# BUILDING PERMIT

Located At 314 LUDLOW ST.

Job ID: 2011-08-1874-ALTR

has permission to Construct an attached two (2) car garage/ addition.

2 North Elevation  
SCALE: 1/4" = 1'-0"

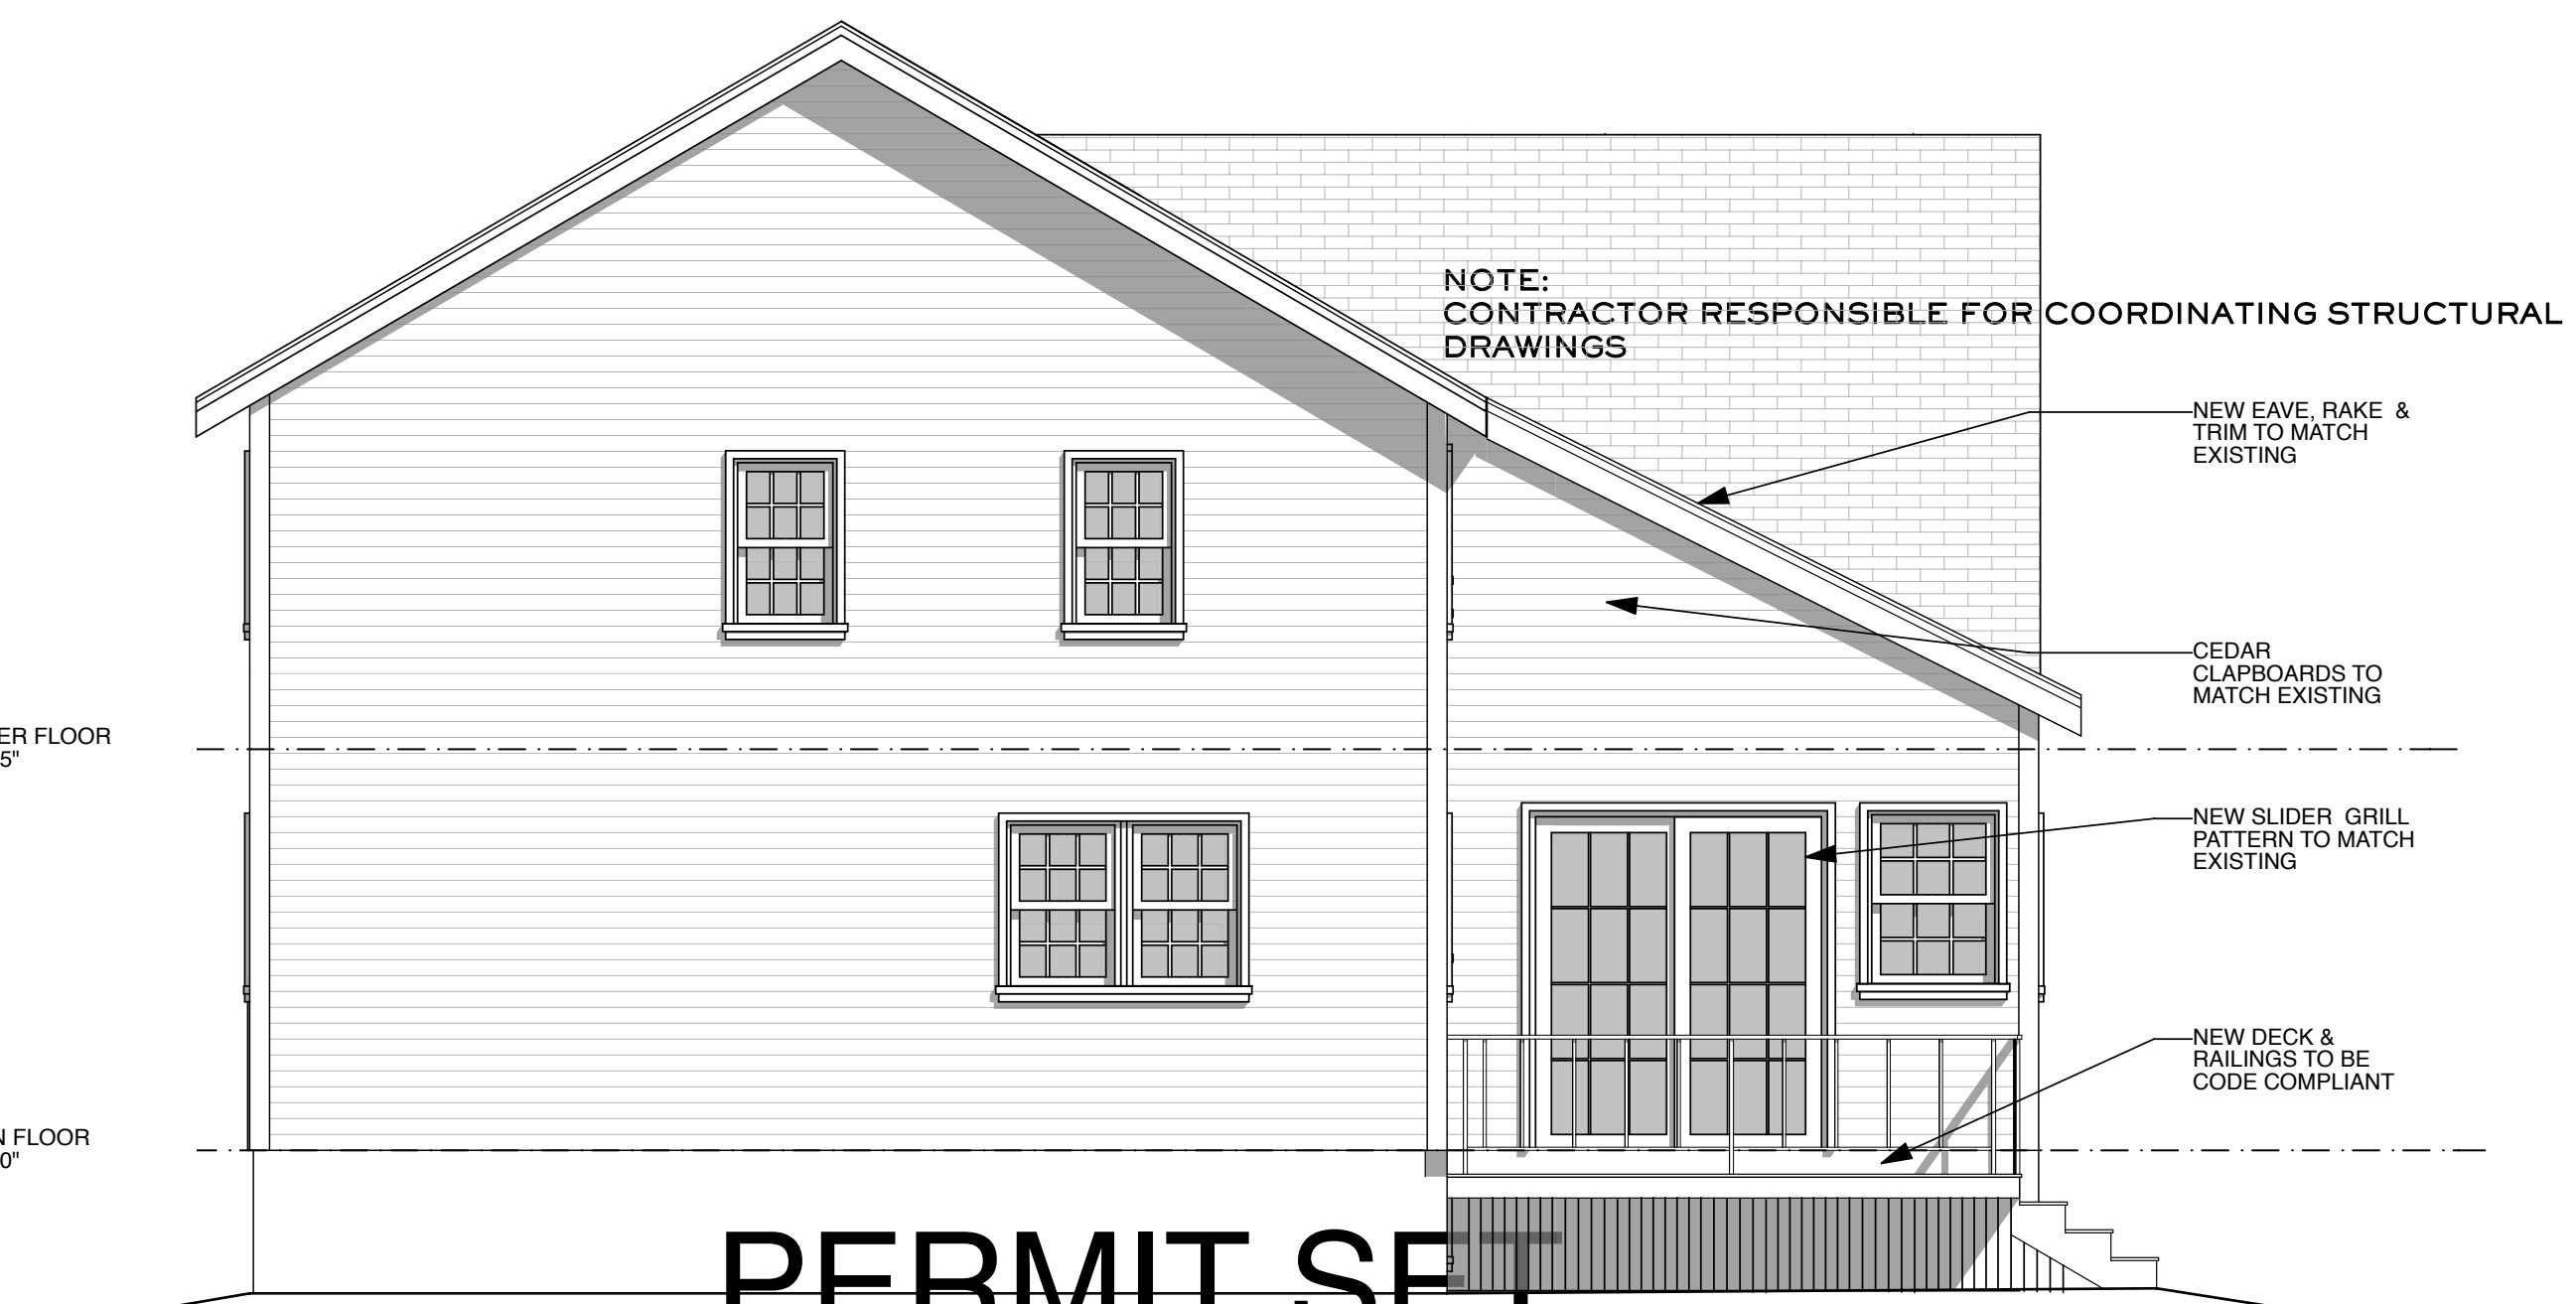
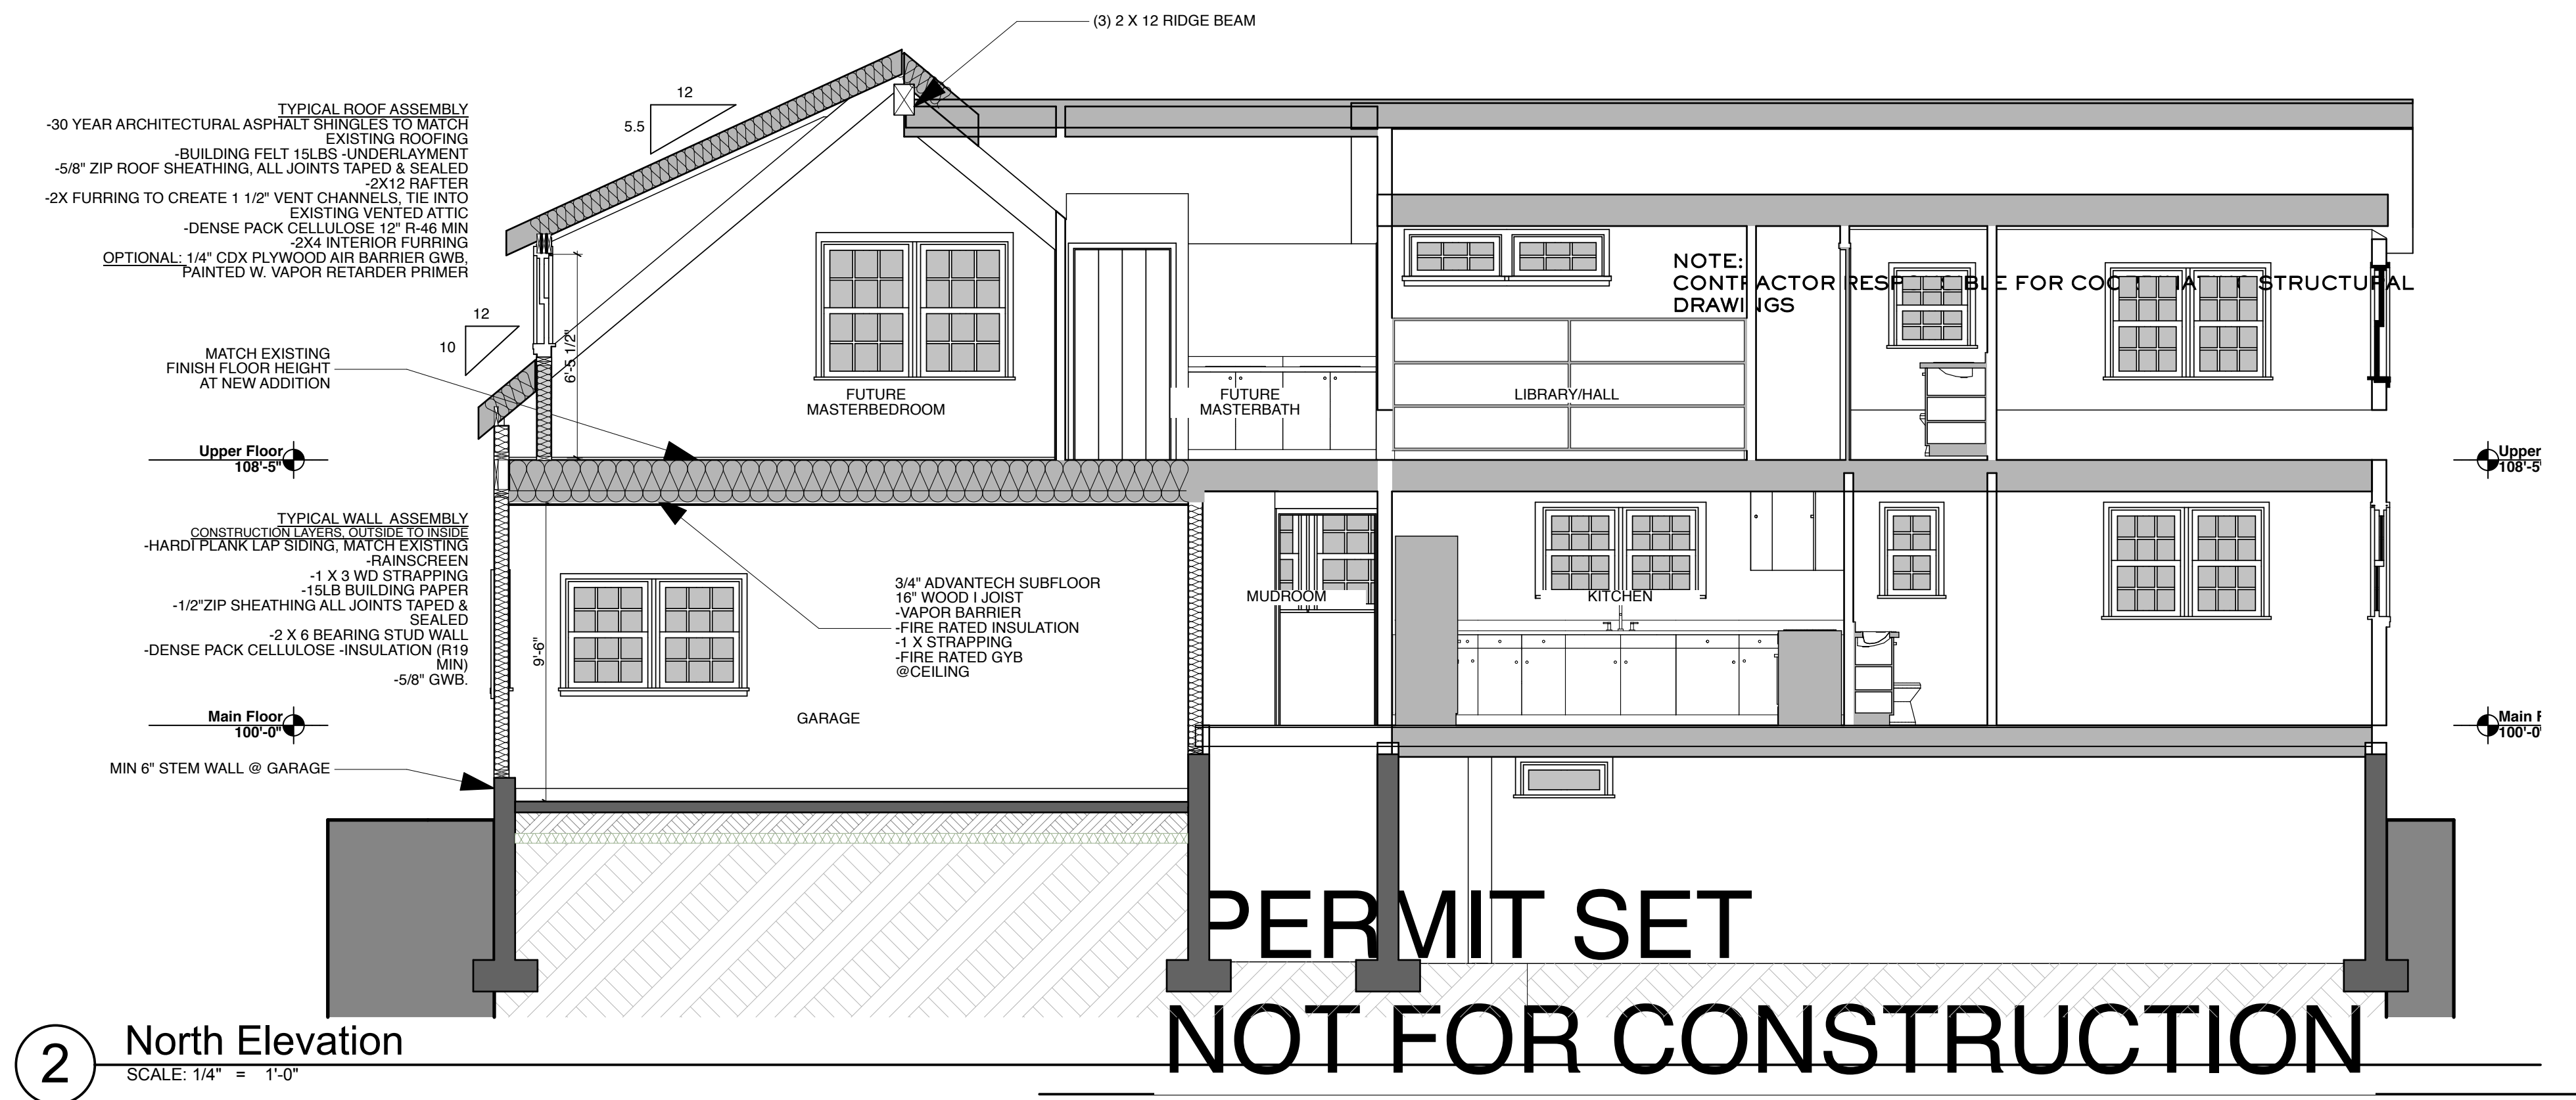
Is the (3) 2 x 12 inch Structural Ridge posted down, Or sitting on a bearing wall w/  
Lally Columns in the Garage?

- > maintain the minimal headroom from the existing second floor to new
- > floor above the garage vs the 2 X 12" @ 16" OC Rafters & (3) 2 X 12
- > Structural Beam? If not we will need a drawn cross section including the

- > Roof Rafter, Framing and connections in compliance with R802.5.1(1) &
- > R802.5.1(8) (showing finished headroom).
- >
- >
- > Are the proposed changes including the addition of any interior stairs?

> Eli,  
>  
> The elevation cannot change without Zoning review. We needs the  
> specifications (Cross-Section) on how the (3) @ x 12 inch ridge beam  
> (for the cathedral ceiling) is being posted-down to foundation. JGR.  
>  
>  
> Jonathan Rioux  
> Code Enforcement Officer/ Plan Reviewer  
>  
> City of Portland  
> Planning and Urban Development Department  
> Inspection Services Division  
> 389 Congress St. Rm 315  
> Portland, ME 04101  
> Office: 207.874.8702  
> Support Staff: 207.874.8703  
> jrioux@portlandmaine.gov  
>  
>  
> >>> <esmall2@maine.rr.com> 8/24/2011 3:11 PM >>>  
> Jon,  
>  
> Just to clarify, no stairs and no deck in the new construction.  
>  
> As for the roof, I just talked to my architect and my builder. The  
> ridgebeam that is perpendicular to Ludlow St. can be lifted to create  
> enough head room for the rafters. Based on my research of the R-3  
> building code, I have a 35' height restriction. My current roof is less

As for the roof, I just talked to my architect and my builder. The ridgebeam that is perpendicular to Ludlow St. can be lifted to create enough head room for the rafters. Based on my research of the R-3 building code, I have a 35' height restriction. My current roof is less than 24'. My builder thinks that we can lift the ridge as needed to allow for the minimum of 7' 5" interior headroom.
